Development Control
Ribbles Valley Borough Council

Your ref: 21.0397
Our ref: D3.21.0397
Date: 14th May 2021

Address: Land at Barrow Brook Enterprise Park, Barrow

Proposal: Proposed new light industrial units/retail trade counter

DRAWING TITLE:
Proposed Site Plan

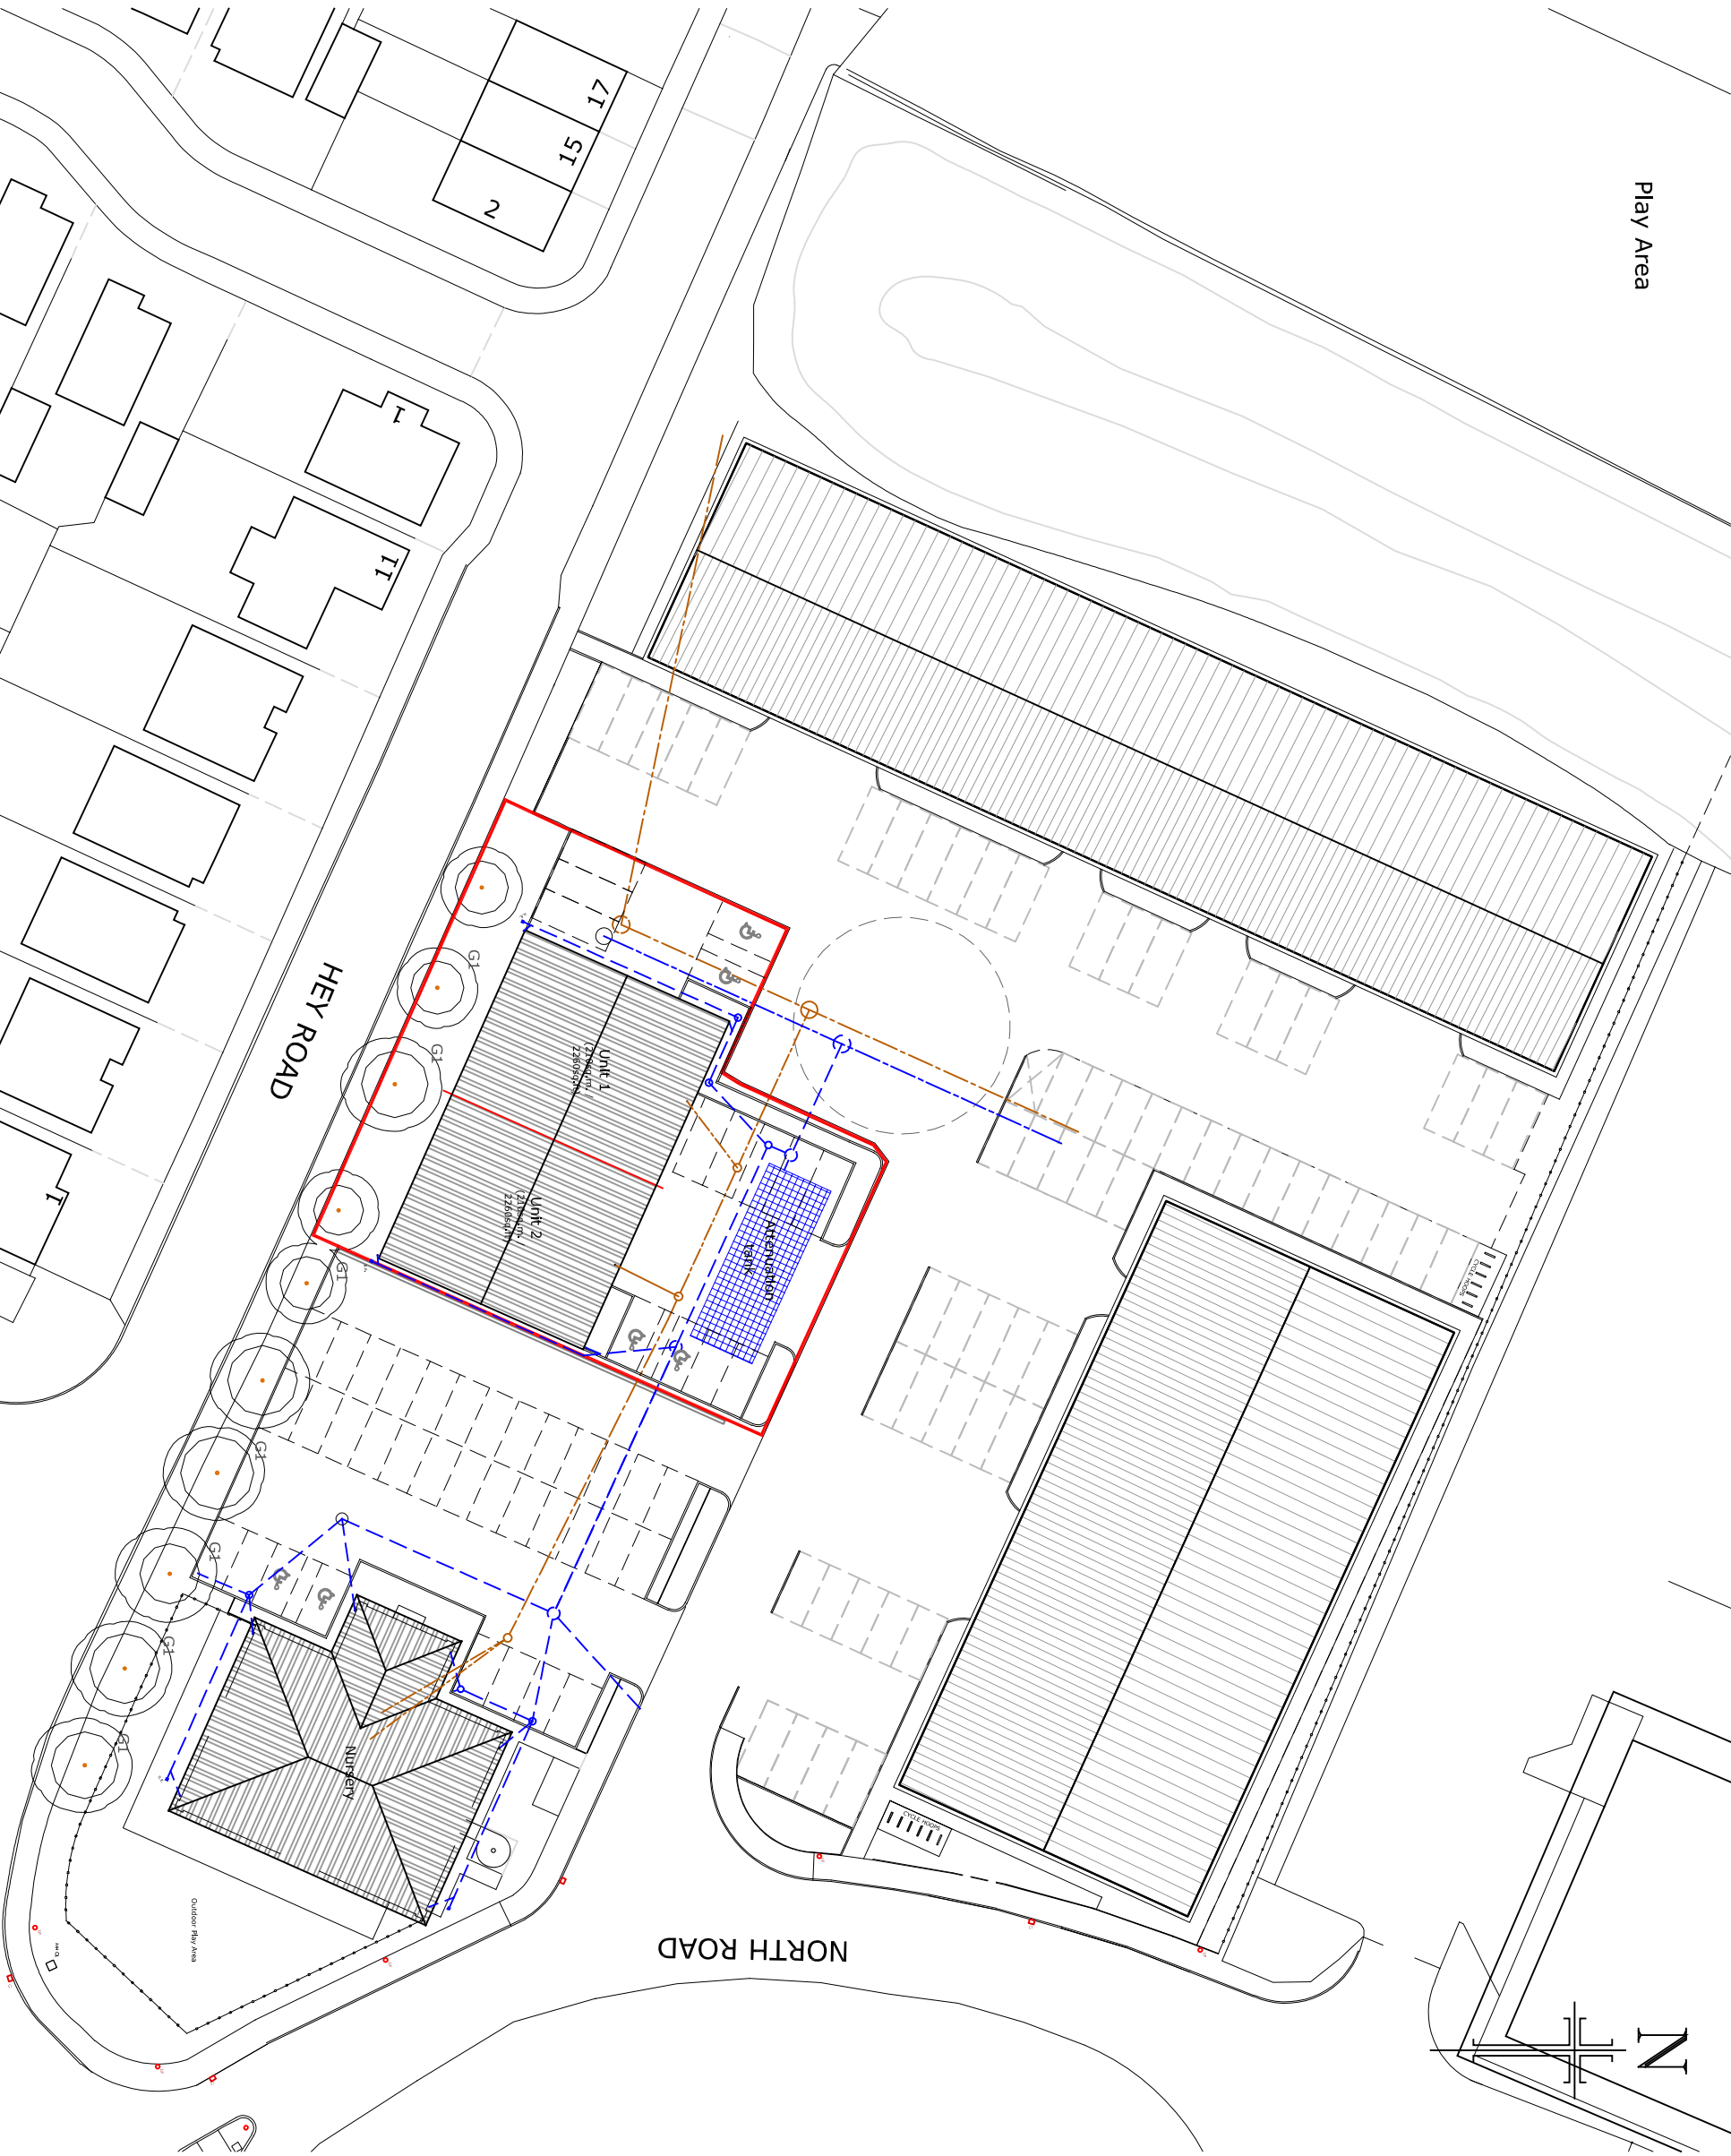
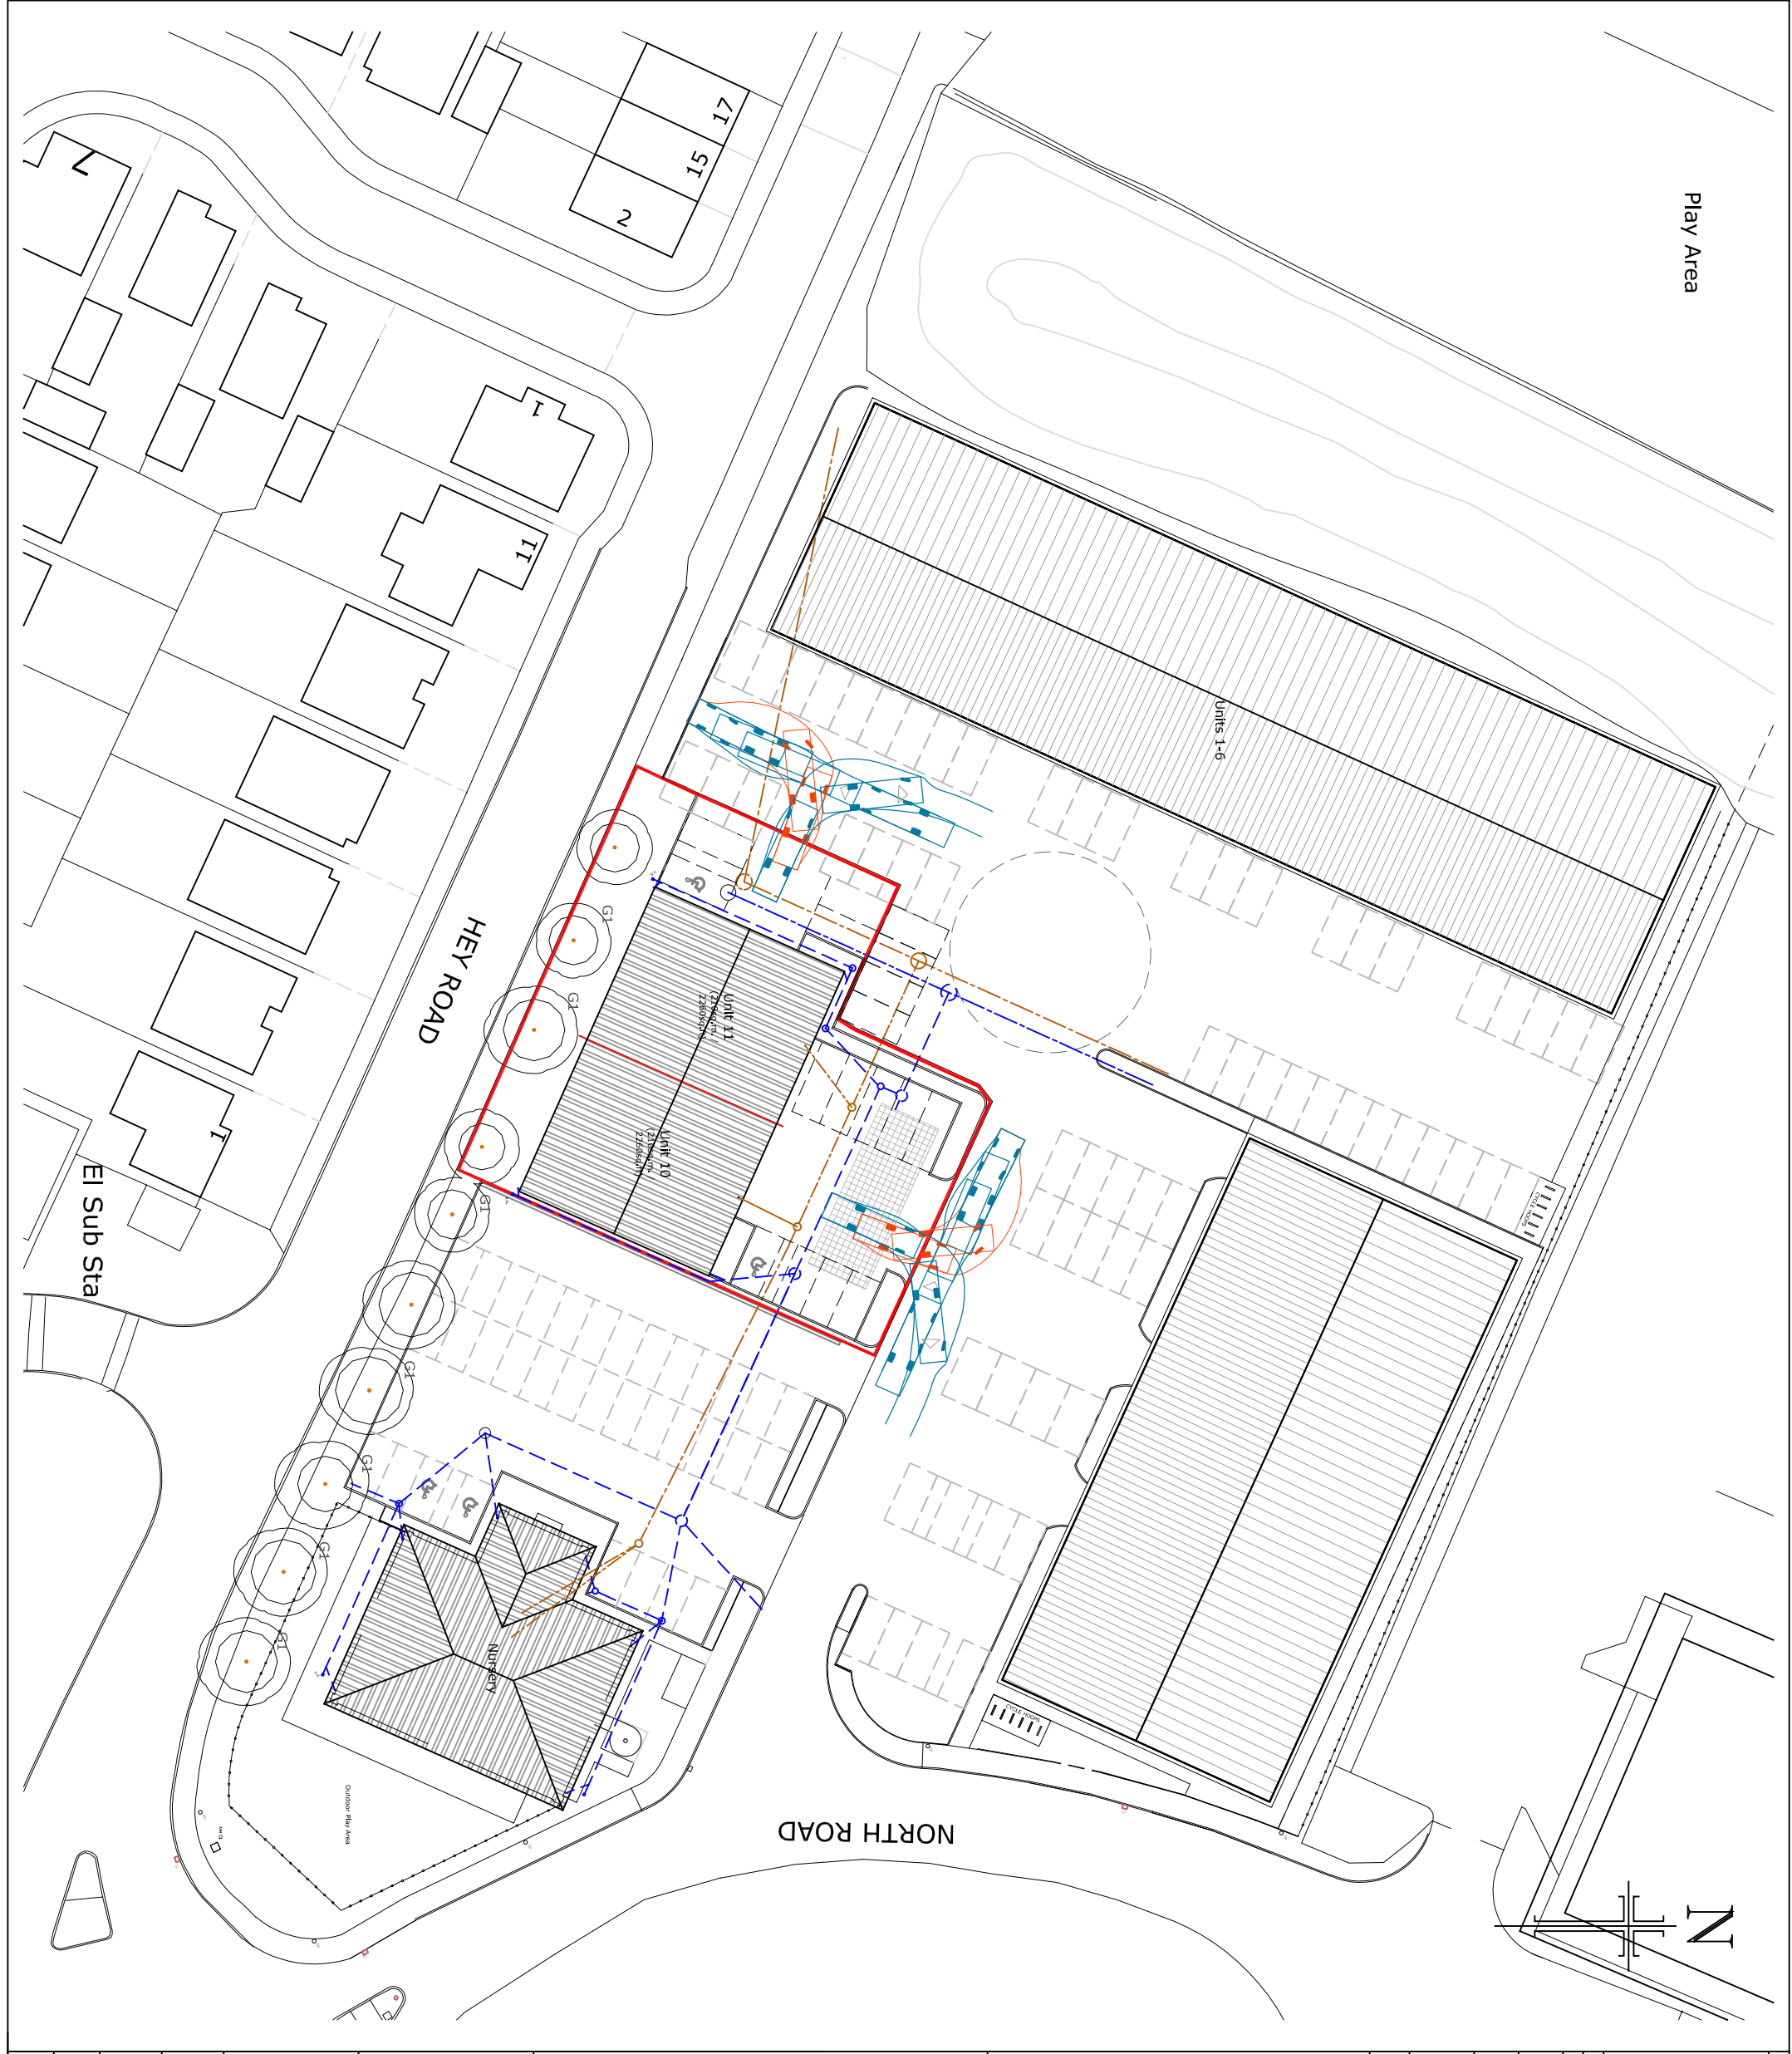
Upon visiting the site I note that the existing car parking layout on site does not match the layout on the site layout drawing. Please amend this as it conflicts with the proposed layout or confirm that the existing layout will be amended.

There is no information in relation to the end users for these unit and Class E covers a wide range of uses. The proposed open plan warehouse space has loading doors which are designed for goods vehicles to access the site. The goods vehicles will need to use the private access road, outside the red edge to reverse turn which we wouldn't accept on the highway. The west facing loading door is set back 7.85m from the red edge which is an insufficient length for longer heavy goods vehicle to clear the adjacent shared manoeuvring area.

A swept path analysis should be submitted for the longest vehicle which is anticipated to be accommodated at these units to show the extent of the area outside and inside red edge which is required for the turning of the vehicles to the loading doors.

The proposed car parking provision appears acceptable subject to the restrictions to the Class E use. There is no secure, covered cycle storage or electric vehicle charging provision. Please include this.

I would request further information in relation to the existing parking arrangement, goods vehicles and a swept path analysis for the longest vehicle. If this is unknown, then the longest road going HGV's vehicle should be used which is a 12m rigid and 16.5m articulated vehicle.
